**RE: Pizza Hut – Coors Blvd & Avalon Rd
Grading and Drainage Plan
Engineer's Stamp Date: 04/14/18
Hydrology File: K10D020D**

Based upon the information provided in your submittal received 04/12/2018, the Grading and Drainage Plan **is not** approved for Building Permit. The following comments need to be addressed for approval of the above referenced project:

PIZZA HUT HUBBEL PLAZA	DRAWN BY DY
	GRADING/DRAINAGE PLAN FOR BUILDING PERMIT	DATE 6/8/2018
	TIERRA WEST, LLC 5571 MIDWAY PARK PLACE NE ALBUQUERQUE, NM 87109 (505) 858-3100 www.tierrawestllc.com	2017015-GRE
		SHEET # C2
RONALD R. BOHANNAN P.E. #7868		JOB # 2017015

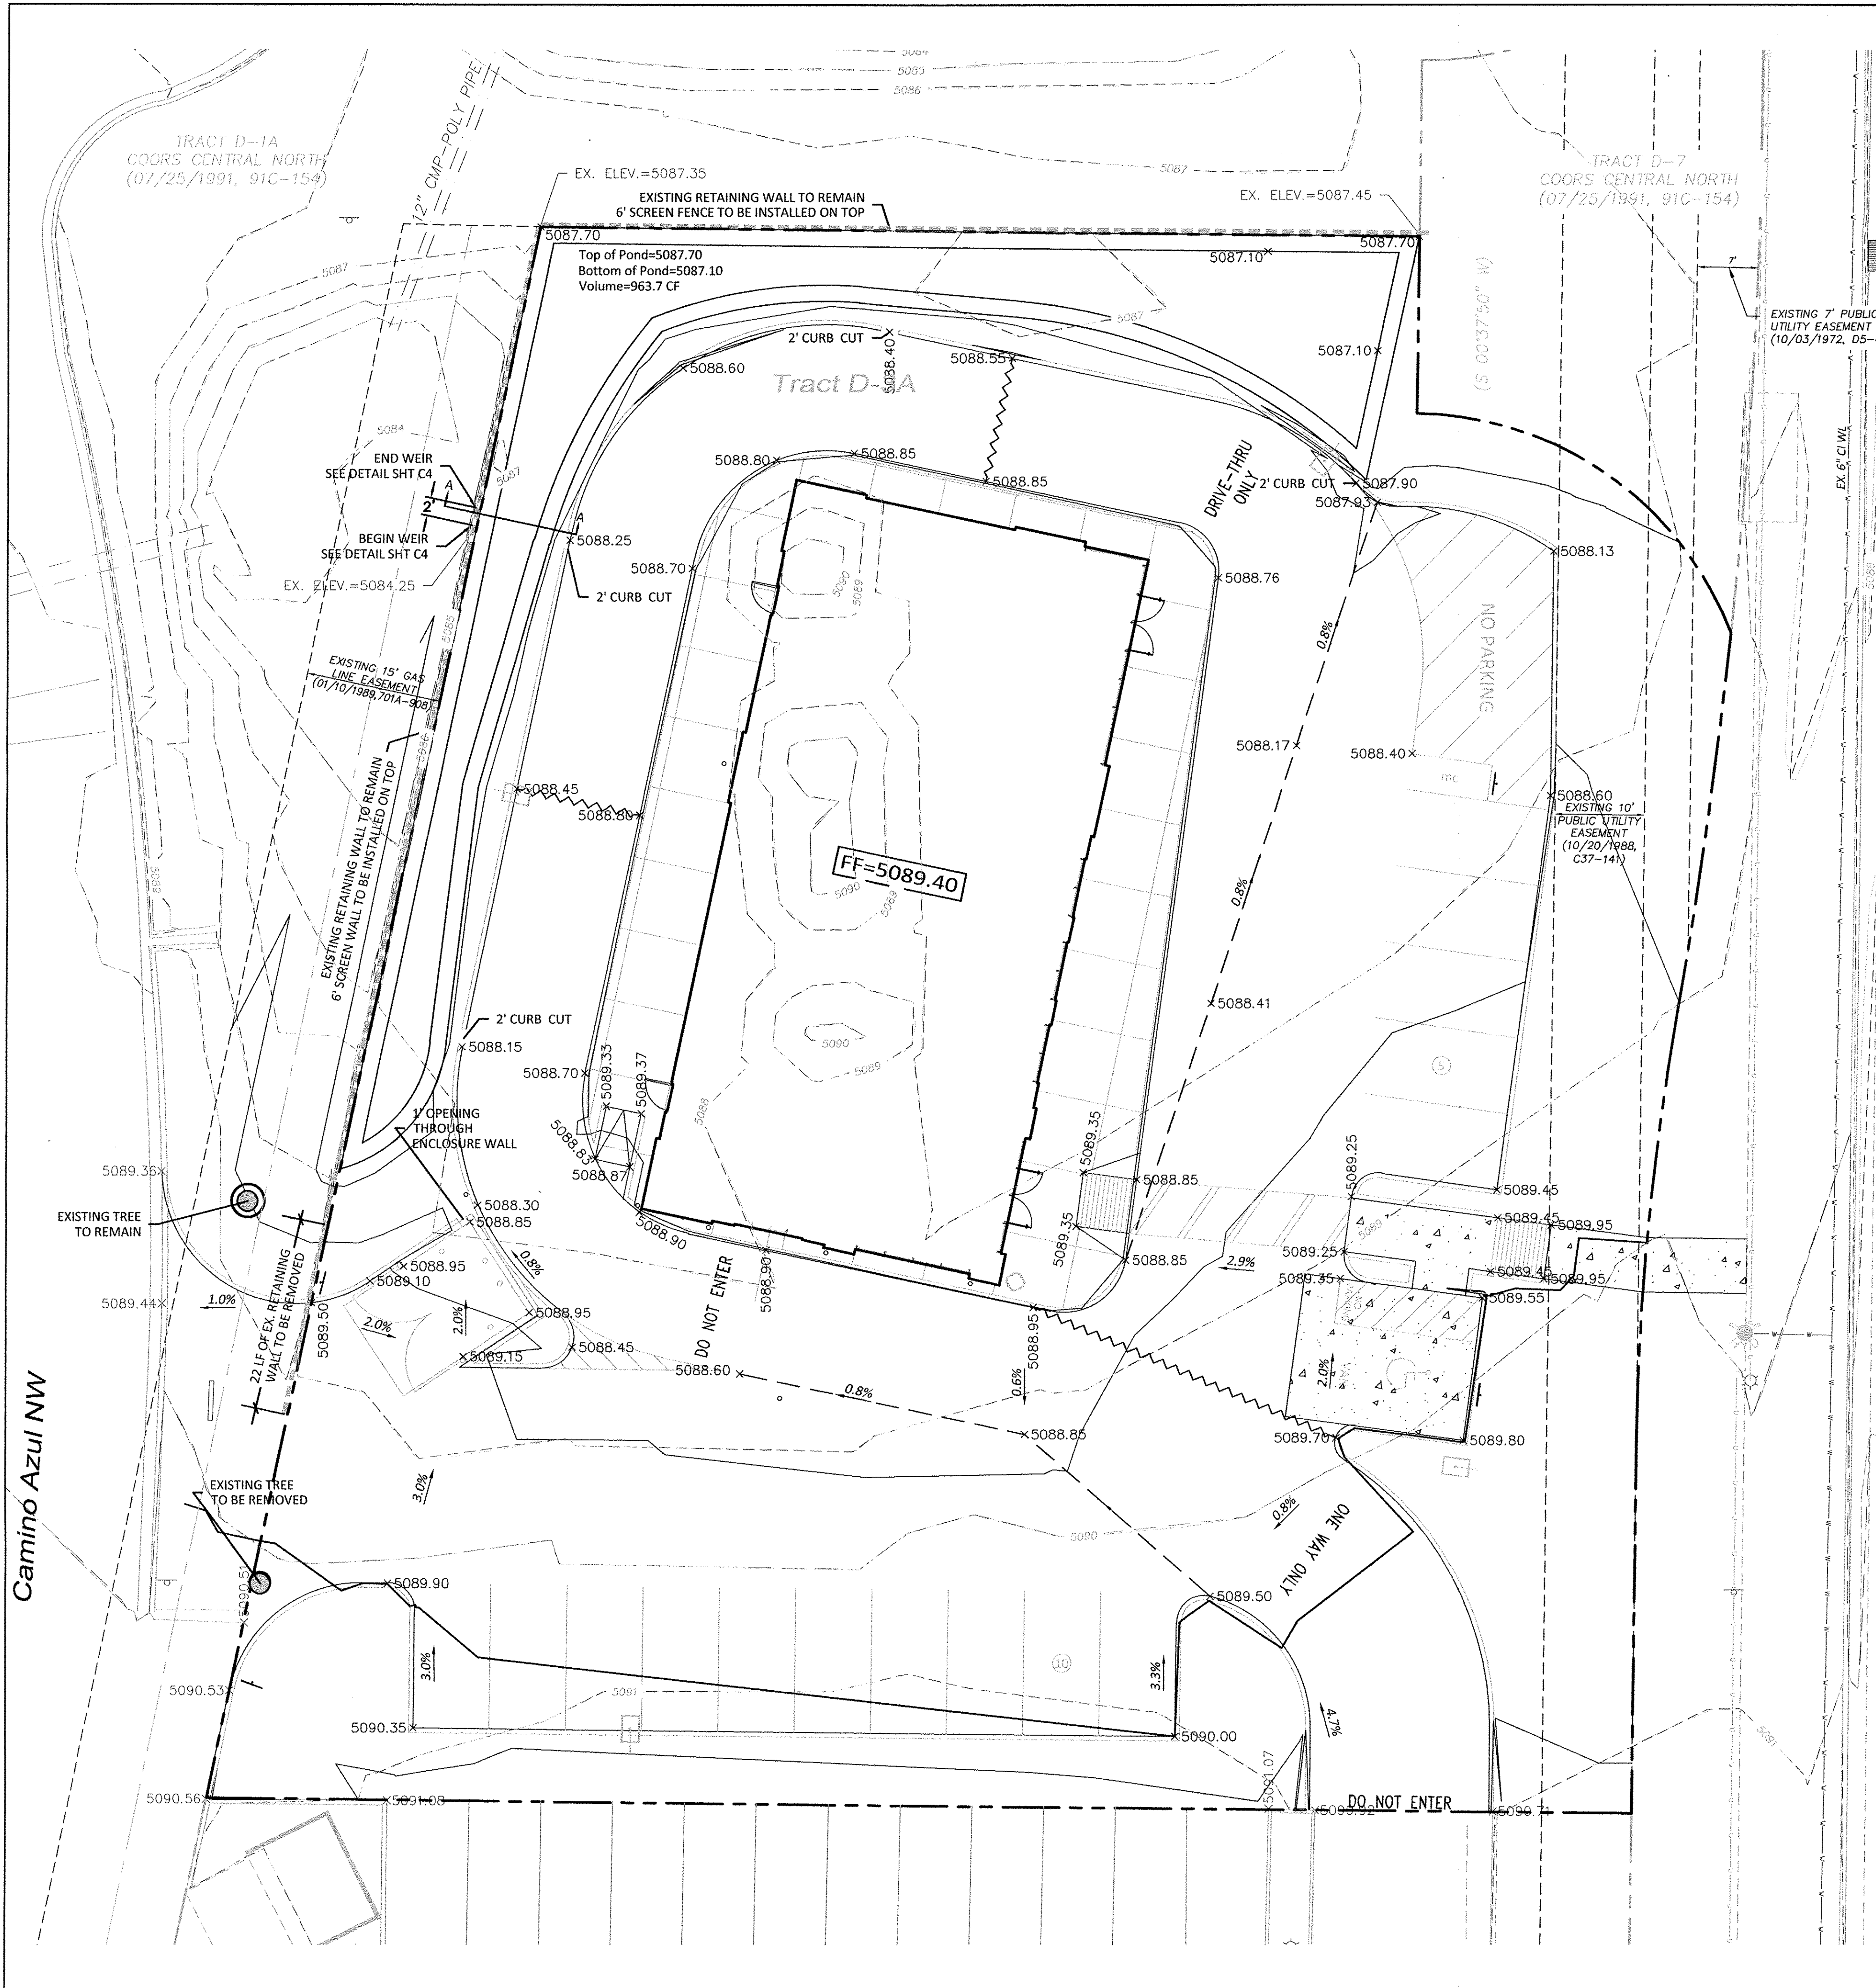
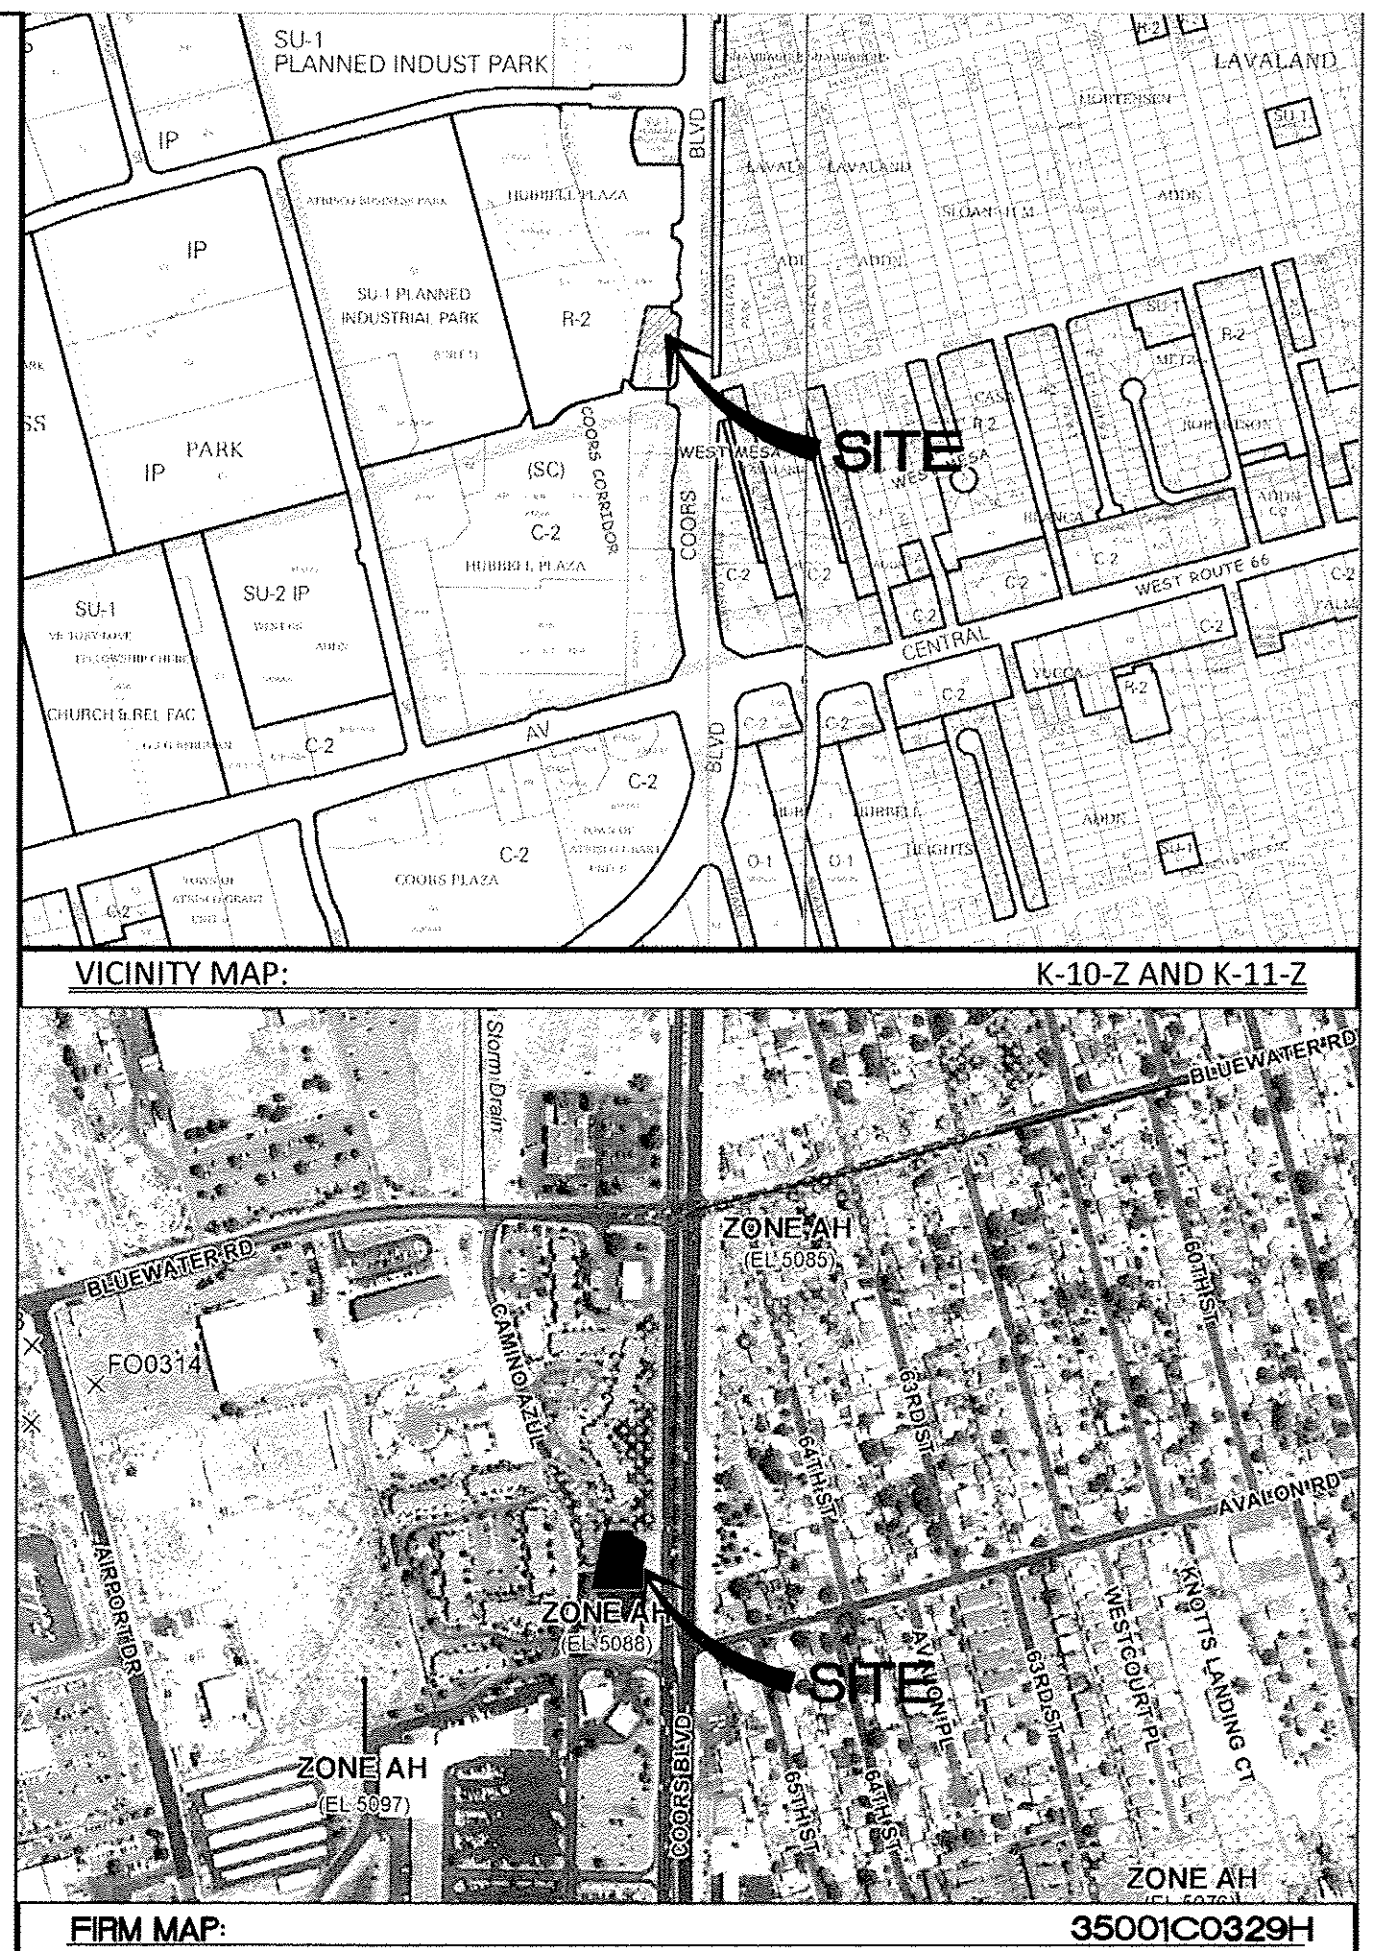
1. According to the latest Firm Map as you have indicated, this site is partially in Flood Zone AH. Please provide a written approval from FEMA prior to Hydrology approval.
2. Please provide Floodplain Permit prior to Hydrology approval.
3. Please fix the site location on the Vicinity Map. The existing Verlero gas station is highlighted.
4. Please show the two existing trees (see photo) and place a note that they will have to be removed.

5. Please provide as-built spot elevations (top of wall and existing ground on either side of the wall) of the existing retaining wall.
6. Please add the provided volume in the first flush pond.

SECTION A-A
NOT TO SCALE

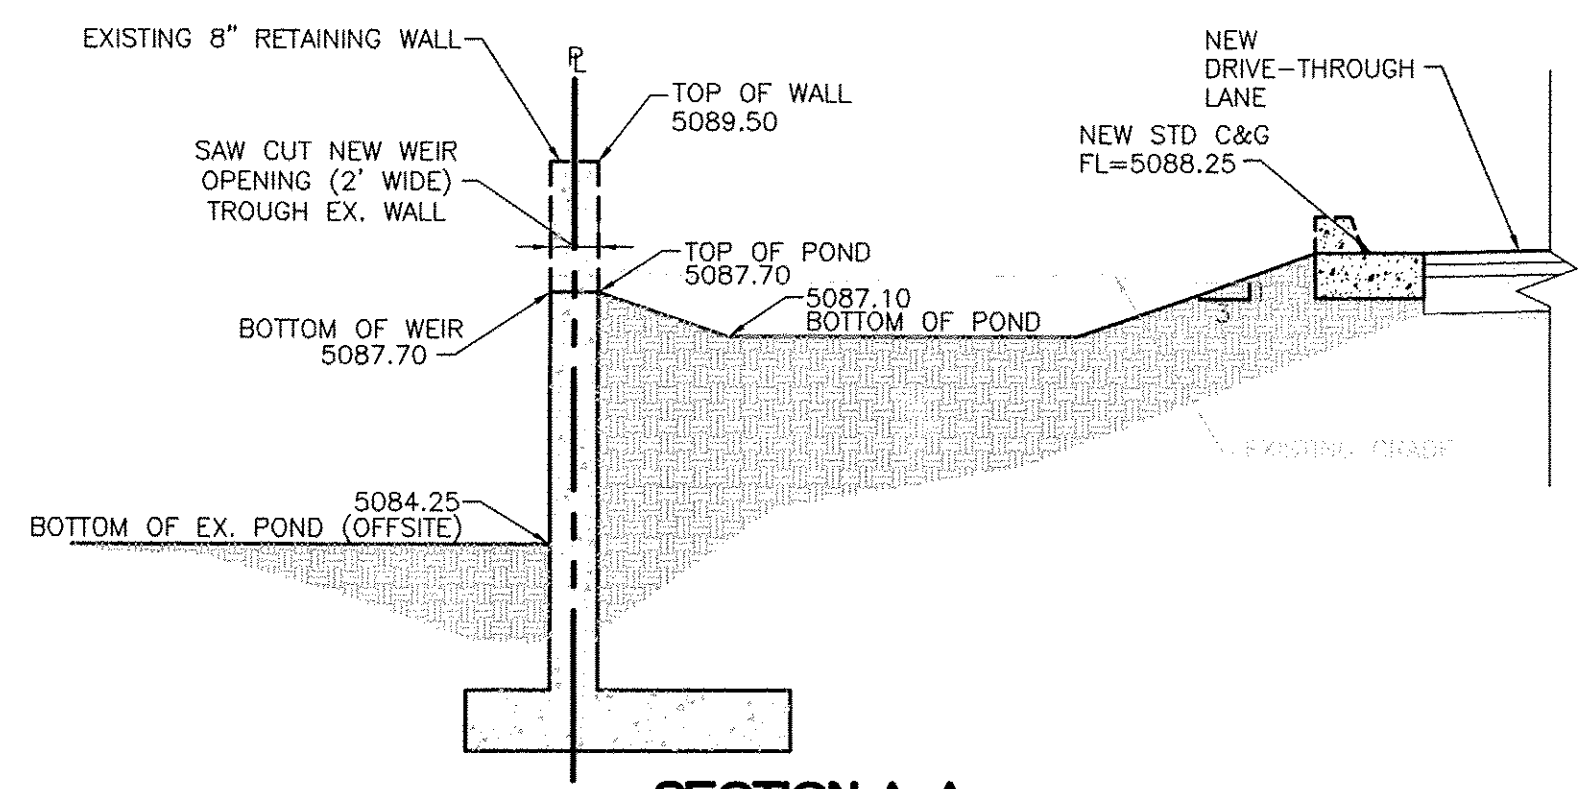
7. For Section A-A, please make these changes:
 - a. Please add the property line.
 - b. Please add the existing wall footer.
 - c. Please provide the width of the existing retaining wall.

- d. It appears that the top of the existing pond next to retaining wall is 5085.70 and not 5087.70. This could be cleared up with the as-built topo shots in comment #5.

- e. Is the existing wall footer conflicting with the proposed pond? If so, than the pond will need to be adjusted.
 - f. Is the wall stable after the existing earthwork excavation for the proposed pond? If not, then either provided for a new wall adjacent with the existing wall or shift the pond so it does not interfere with the existing wall.
